**Addendum No. 4**

RE: Contract # C204177

**Carteret-Craven Counties (R-1015)**

US-70 (Havelock Bypass) From North of Pine Grove to North  
Of Carteret County Line

**SITE #4 -L- STA. 347+00
(2-115Kv)
SEQUENCE #3**

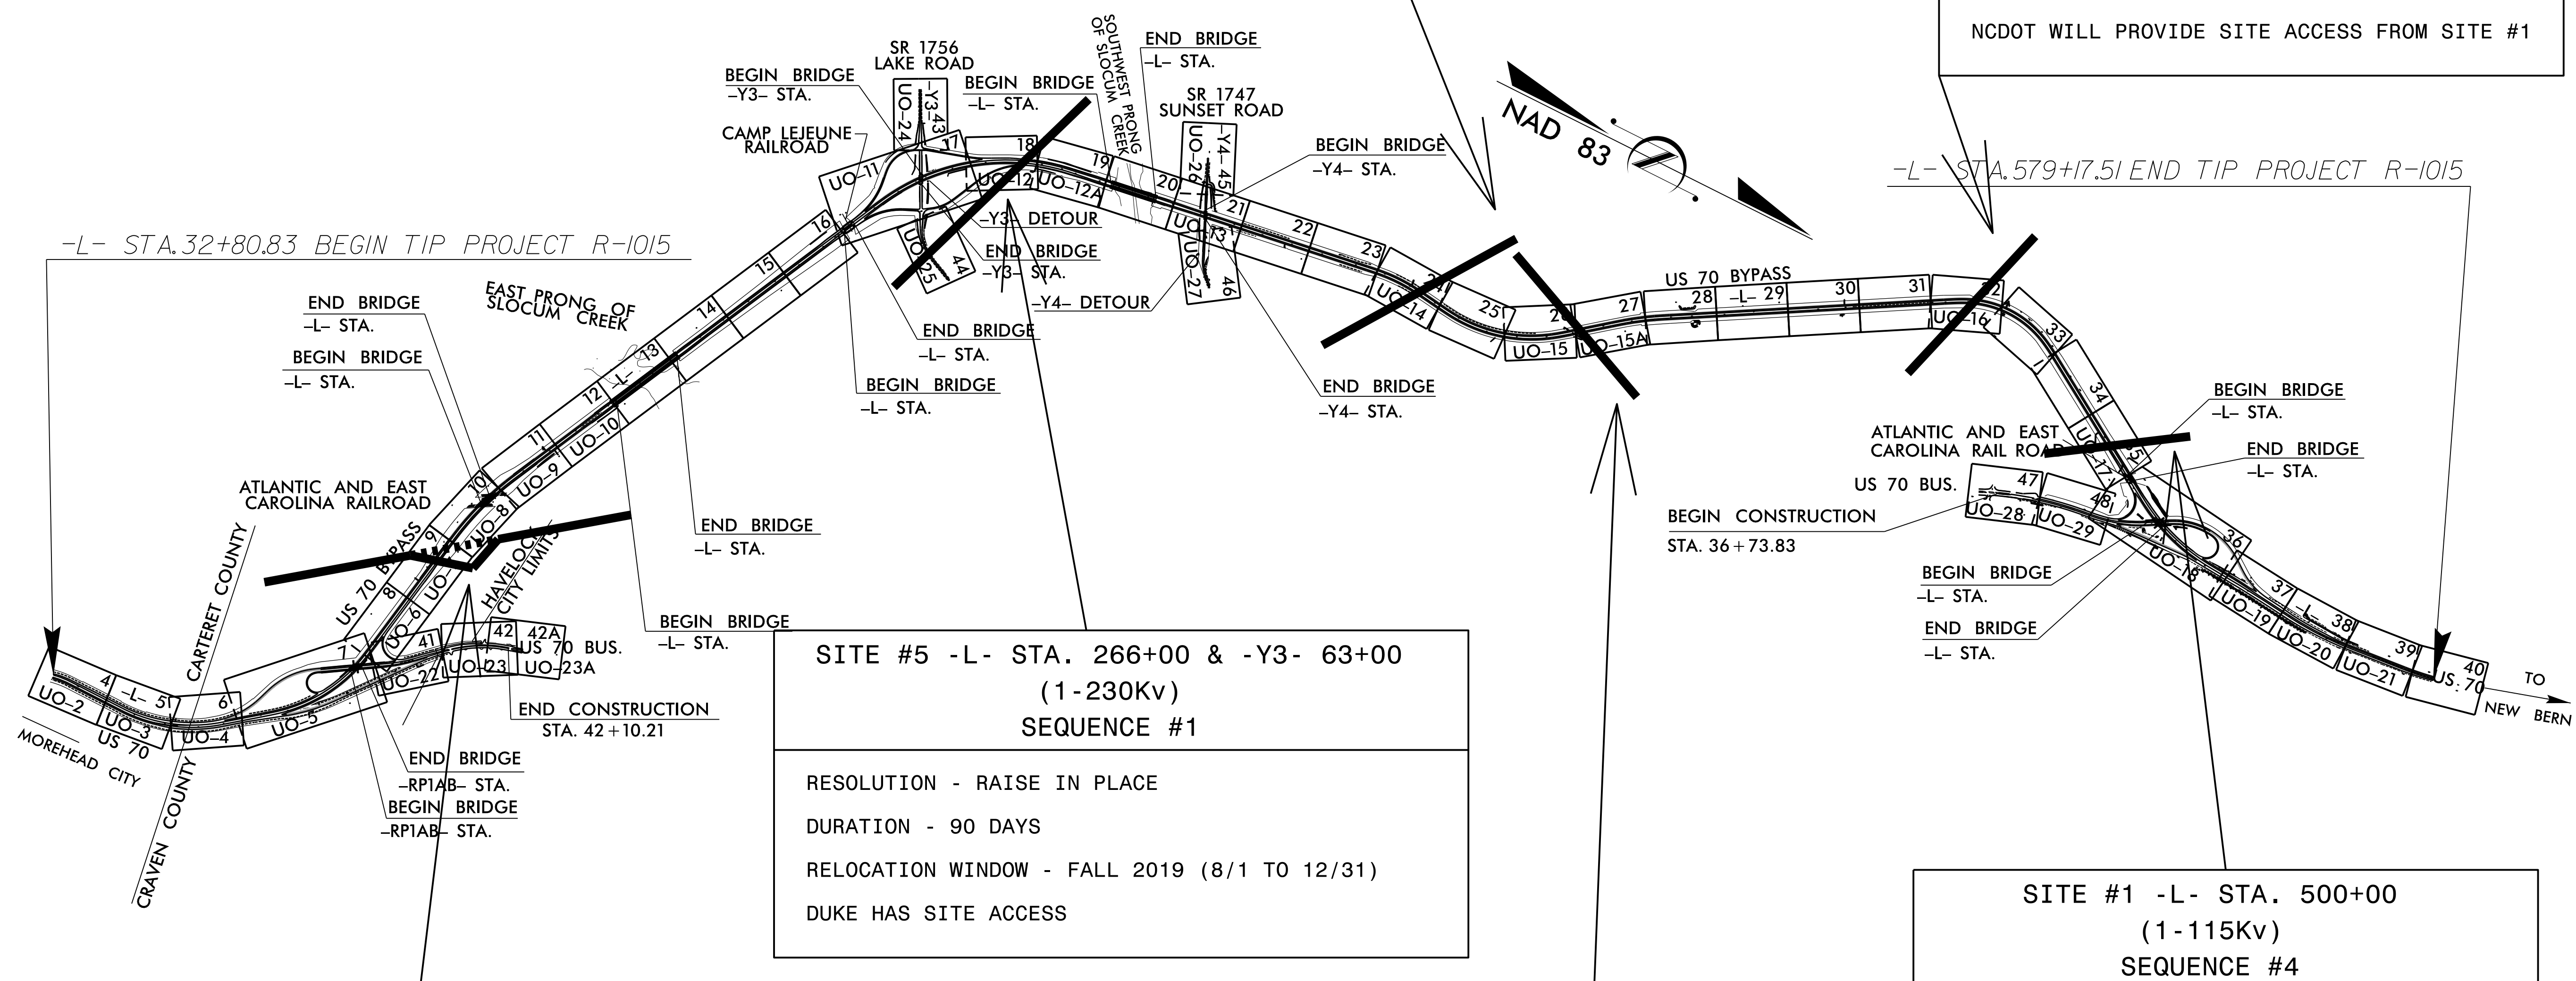
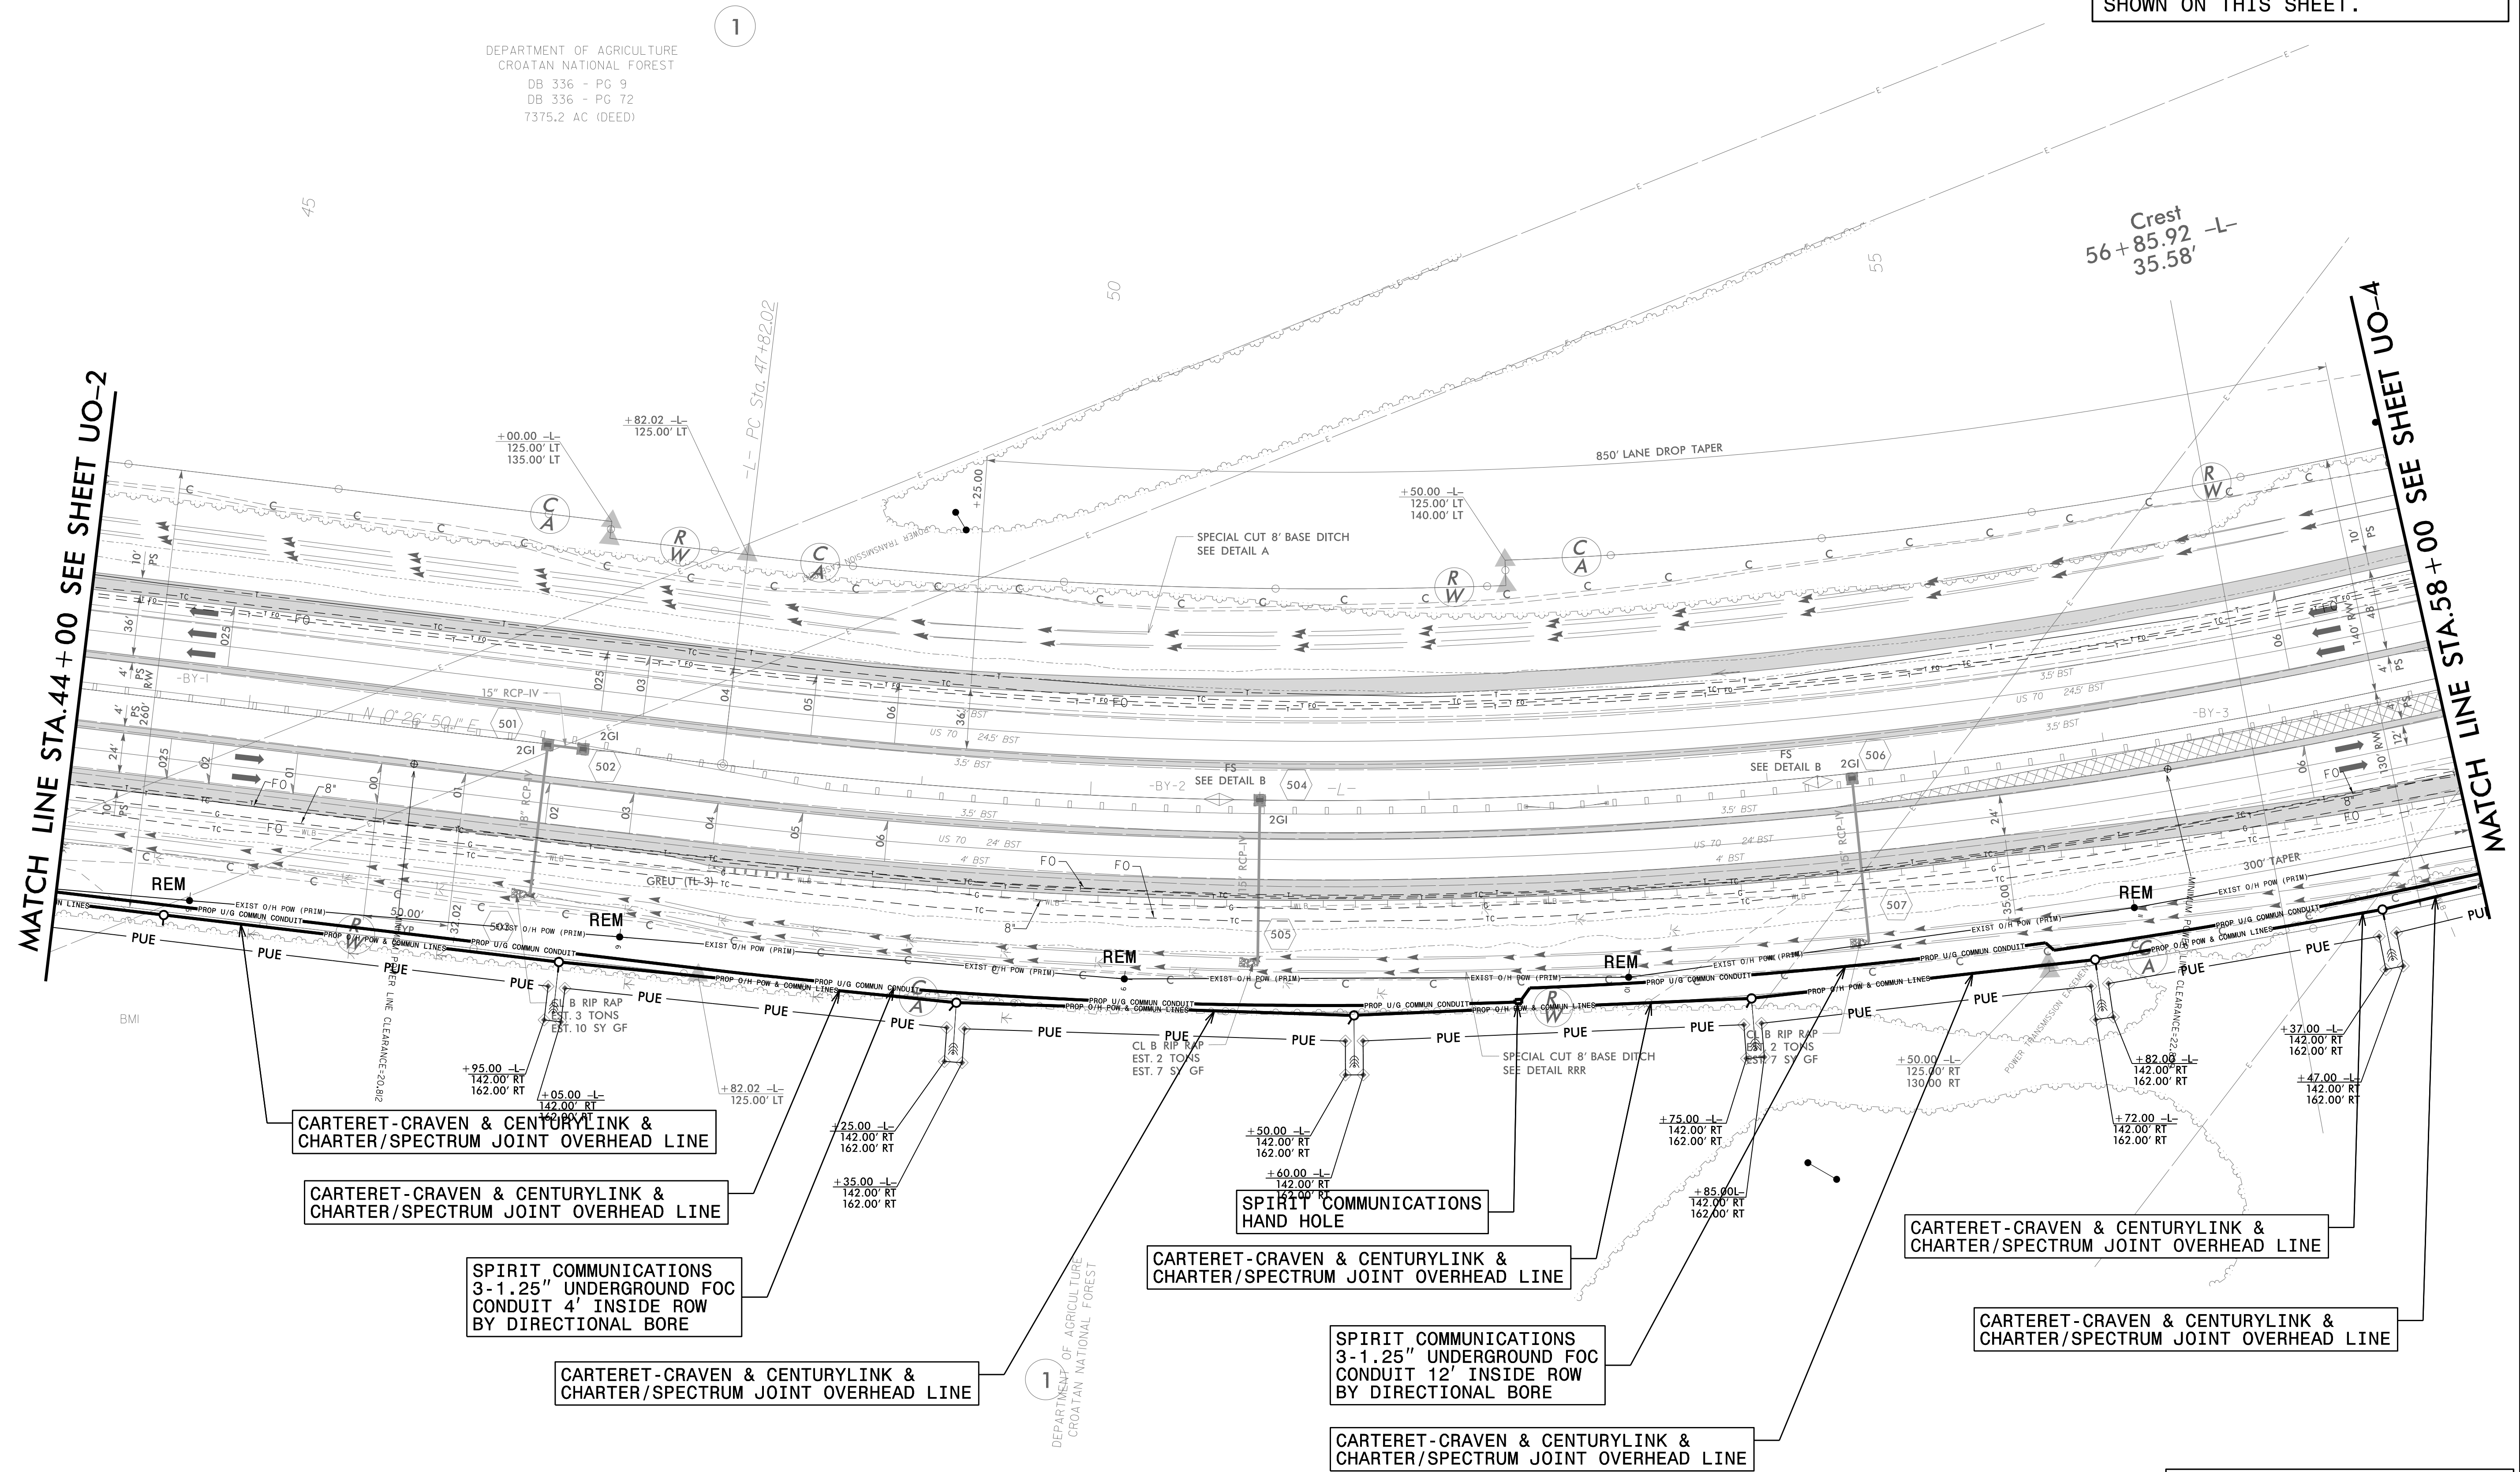
Sheet No.	Revision
1 (Title sheet)	Revised the letting date to April 16, 2019
New UO-1A	Added sheet for Duke Energy Transmission Site Locations and Sequencing
